From: Simon Davis
Sent: 17 May 2019 16:18
To: Planning.Responses
Subject: AL/27/19/DOC - GTR DENMANS LANE FONTWELL
Attachments: EPSON297.PDF

From: John Carver [REDACTED]
Sent: 17 May 2019 16:07
To: Simon Davis [REDACTED]
Subject: RE: AL/45/18/PL GTR DENMANS LANE FONTWELL

FOUNDATION NOTES :-

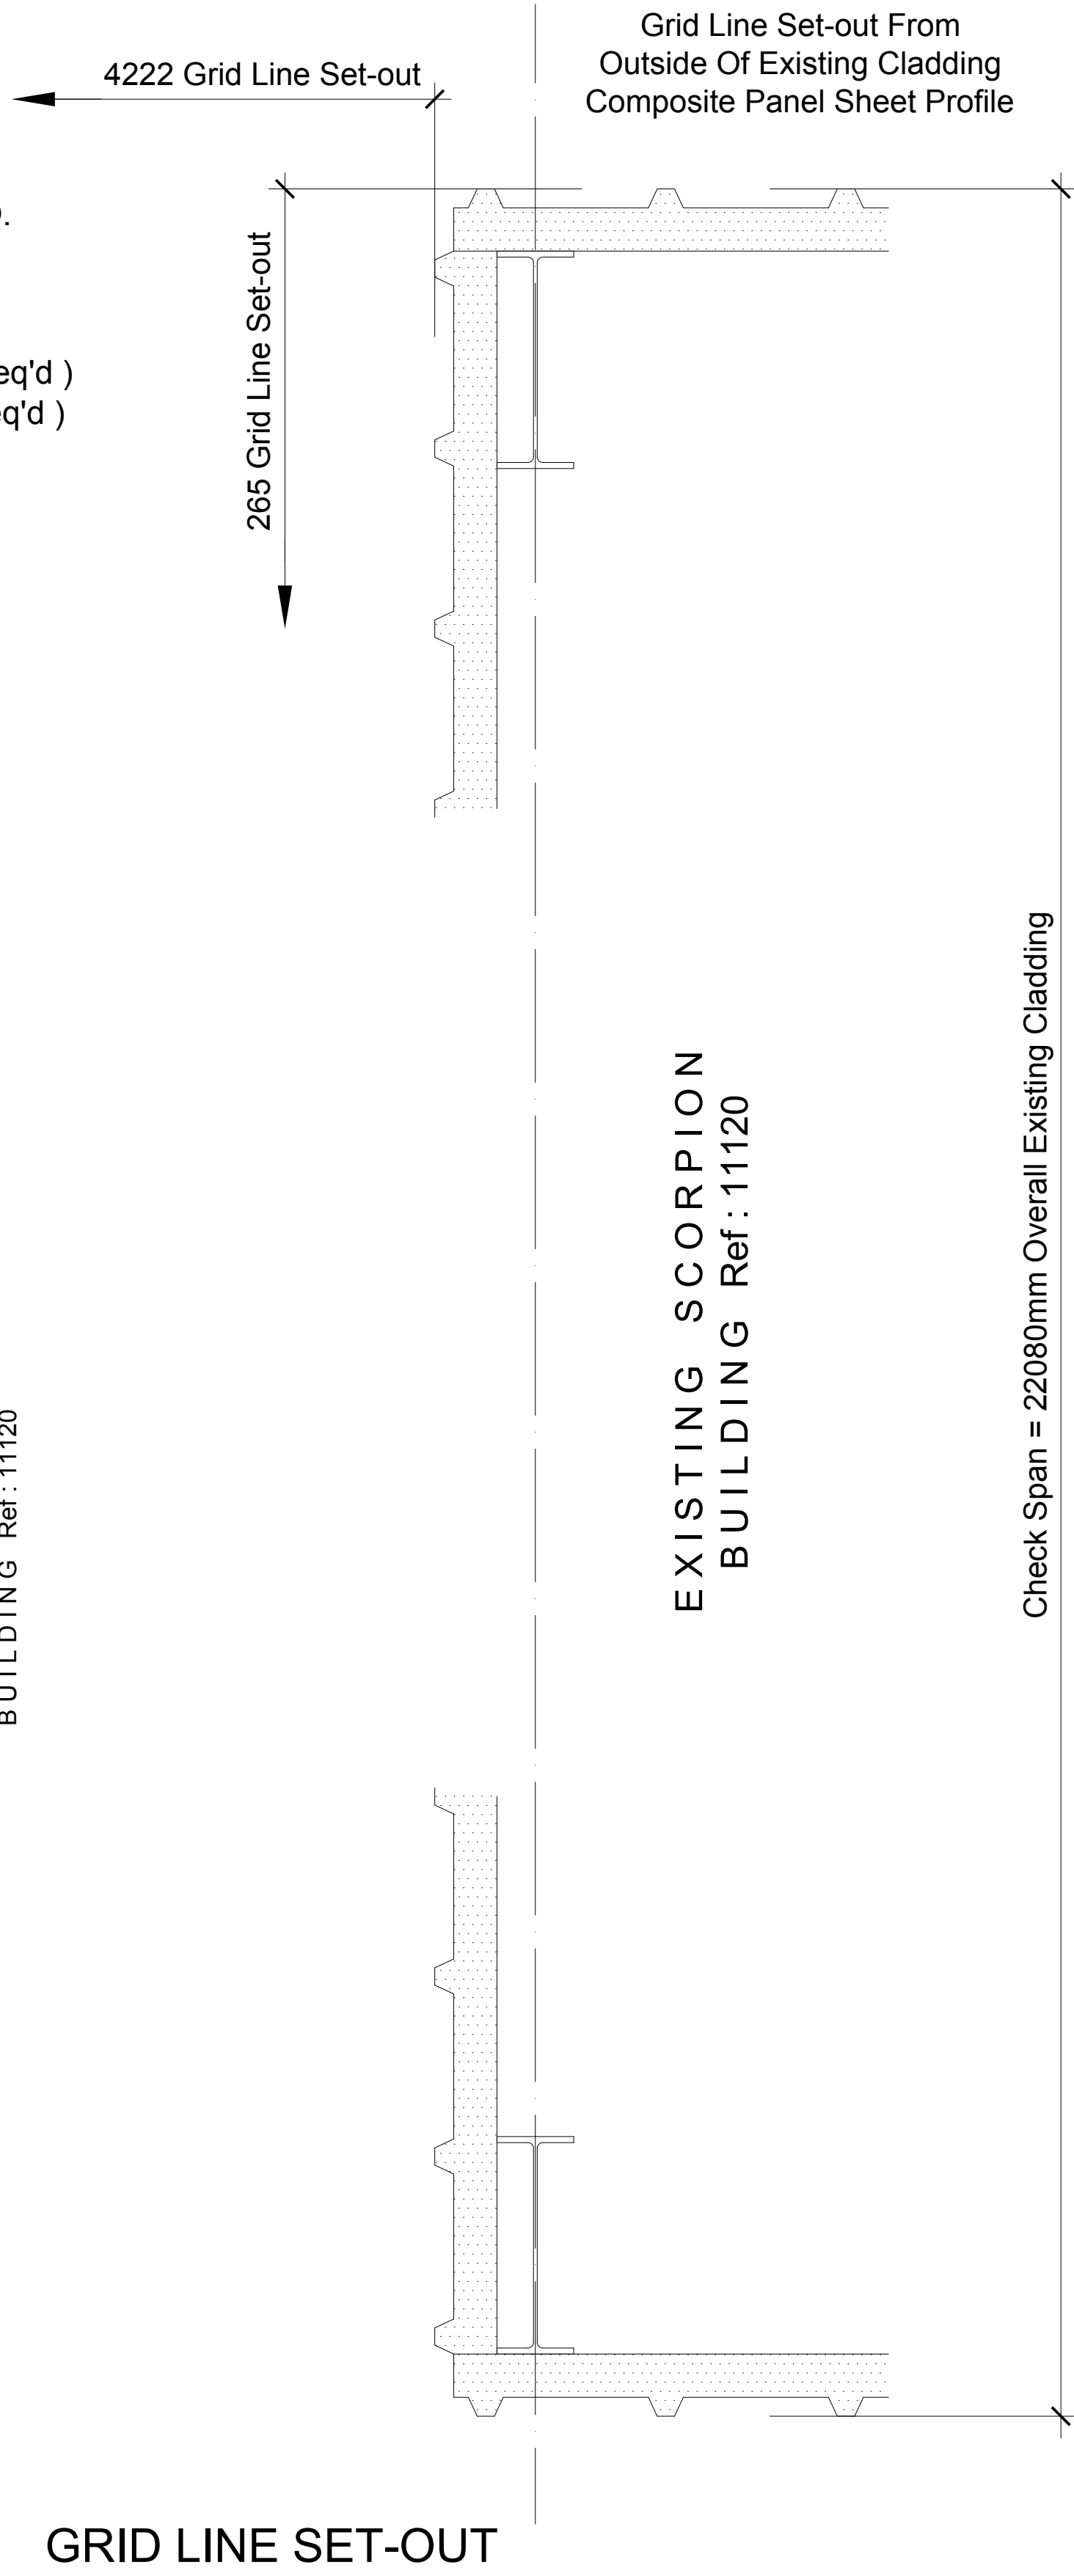
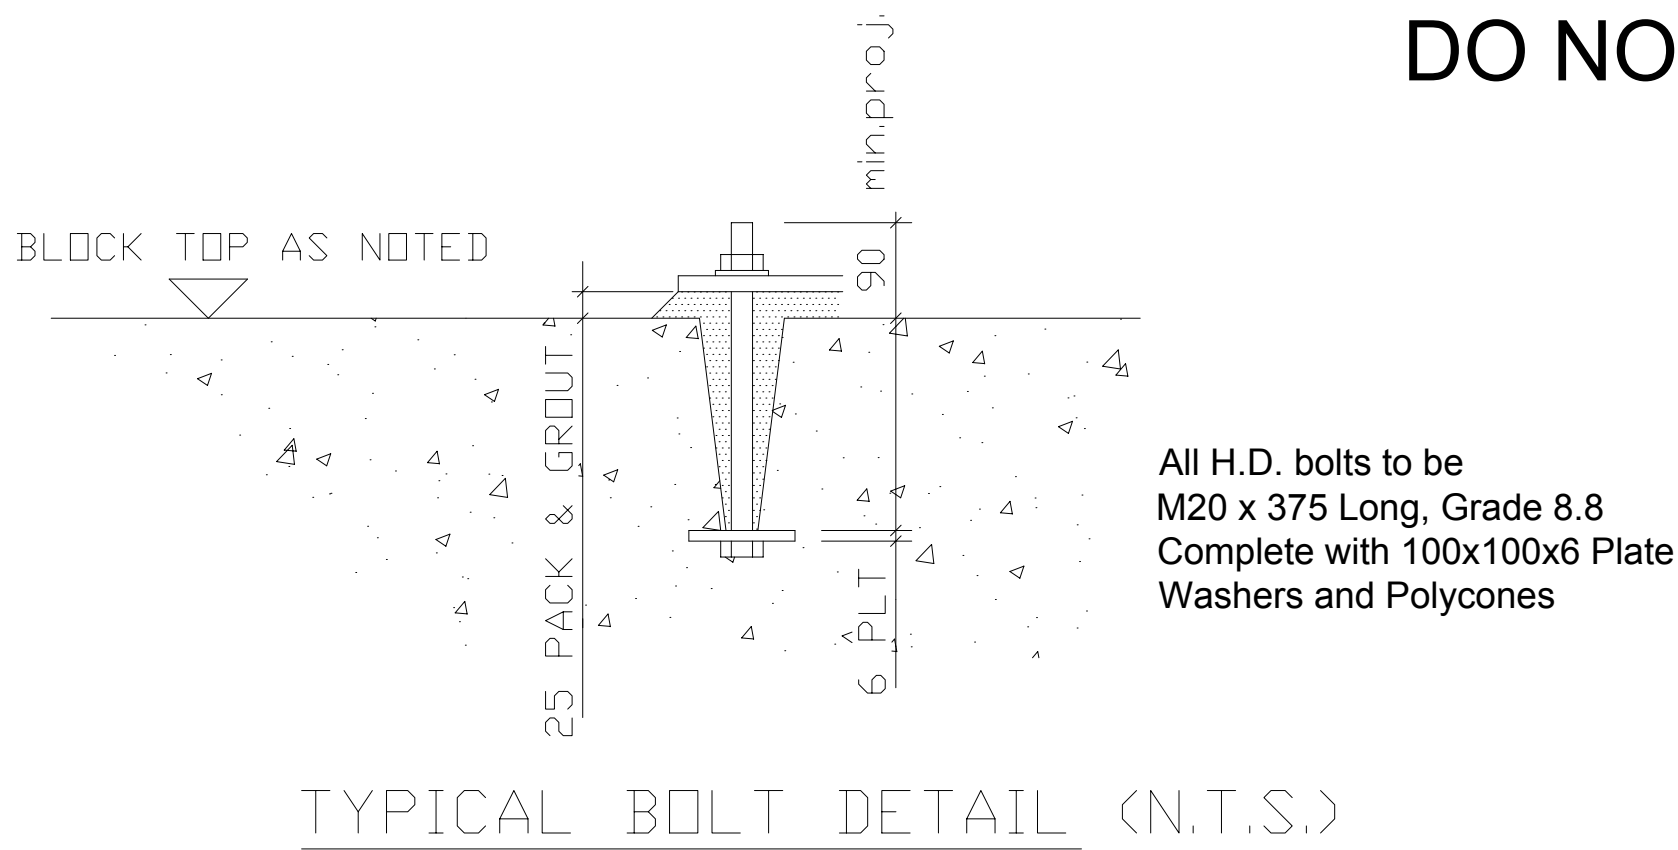
Regarding condition 08, this only requires discharge if you are using piling or other foundation designs using penetrative methods. You state that piling or trenching will not be used but you are proposing a foundation depth of 1.75m. Therefore, do I assume that you are using a penetrative method? We have consulted the EA and I have not yet heard from them so I will chase today.

+BLOCK/SITE PLAN
AREA 130m x 130m A3
SCALE 1:500
CENTRE COORDINATES: 494586, 107083

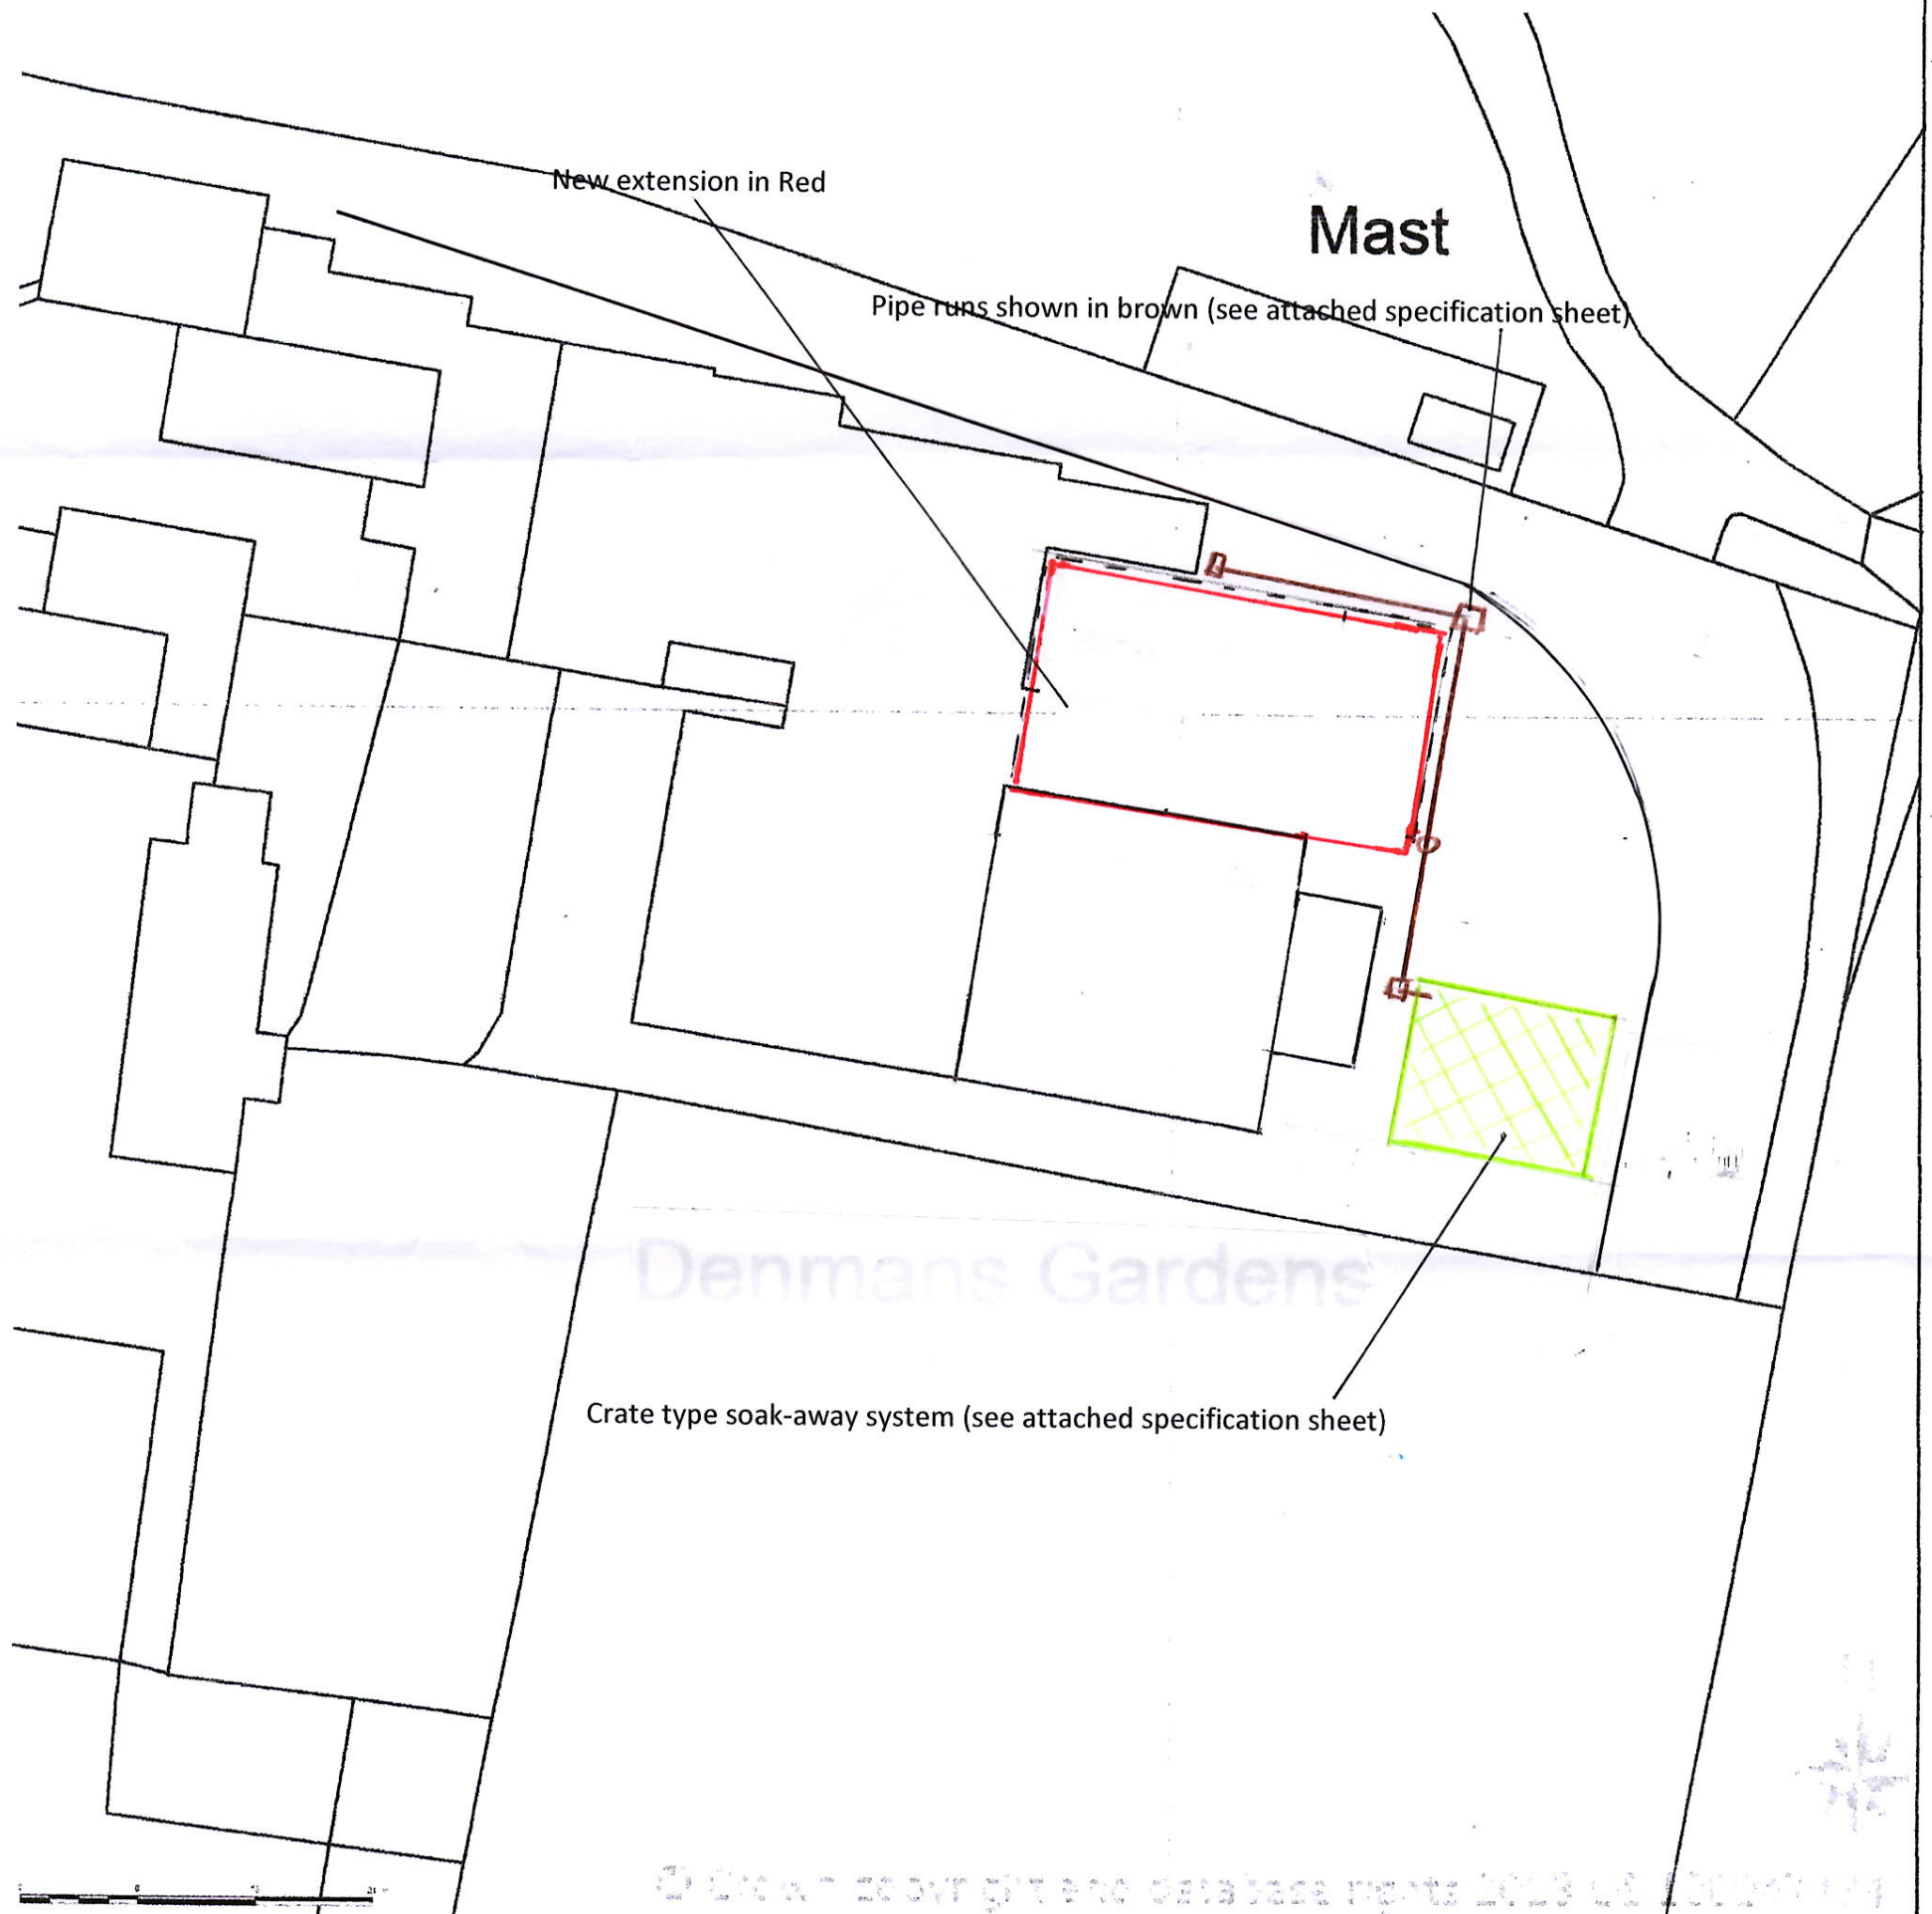
Thanks for these. However, the A3 portrait template block plan does not appear to show anything – can you check please.
